Will & Co

I am writing with reference to the attached submissions (excluding some of the civil plans) that you sent earlier this month to address the conditions of the Planning Board's approval for this this project. My comments IN CAPS and are set in the context of the relevant condition:

i. That the applicant shall confirm which entrance is the main entrance and revise this main entrance to meet the R6 Design standards as outlined in the Design Review comments, and to meet the Site Lighting Standards of the Technical Manual, with the revised proposals submitted to the Planning Authority for review and approval prior to the issuance of a building permit; and

**BICYCLE HITCH DETAIL**  
NOT TO SCALE

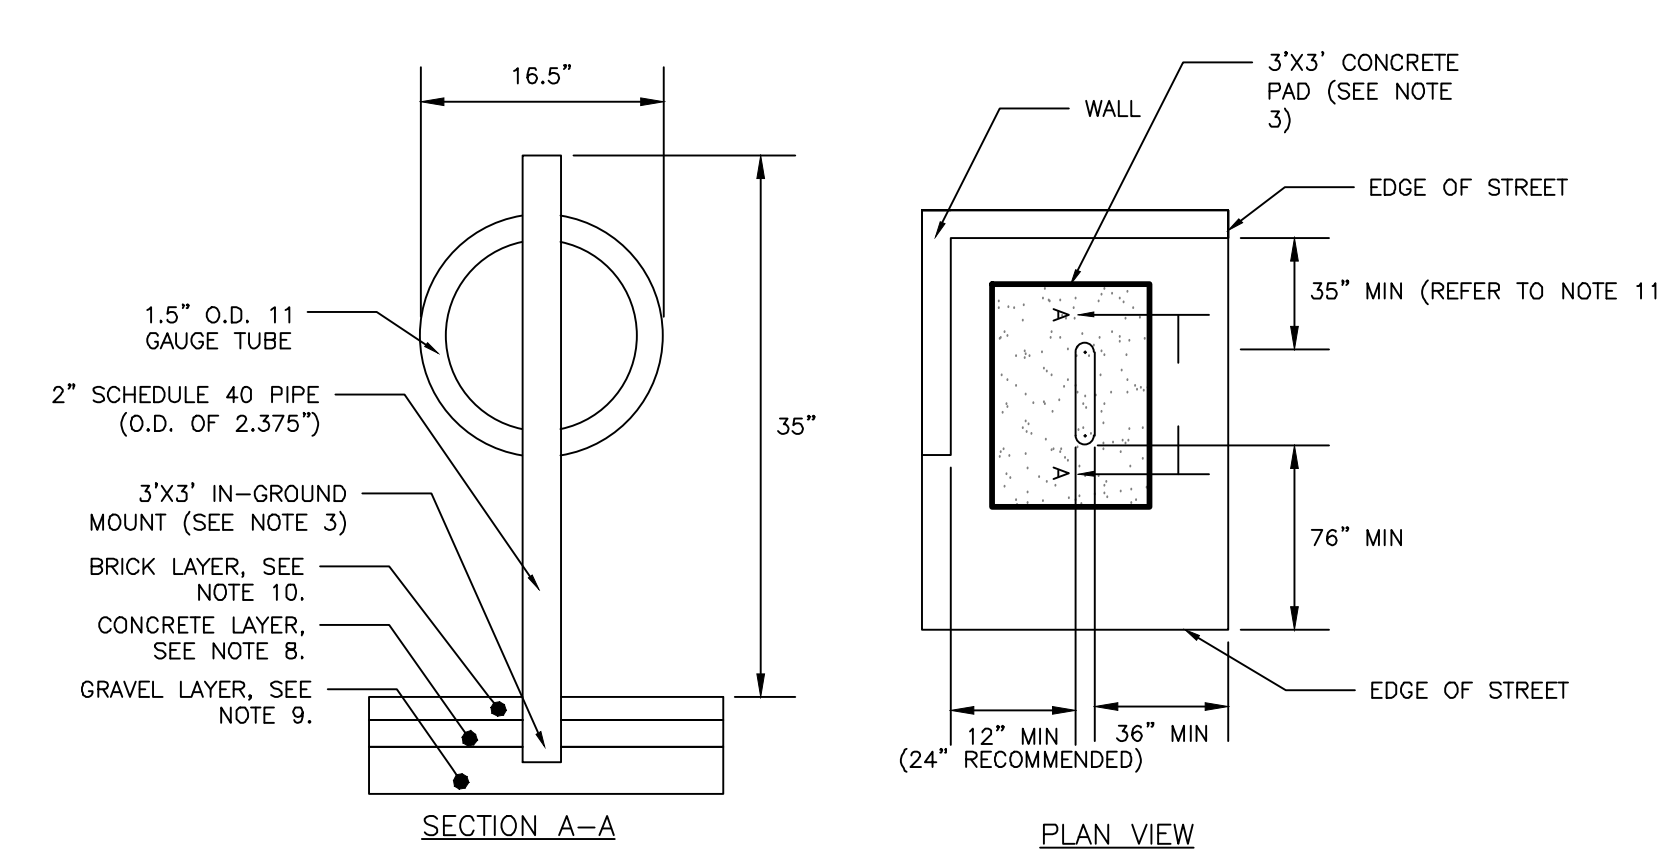
THESE ARE OK
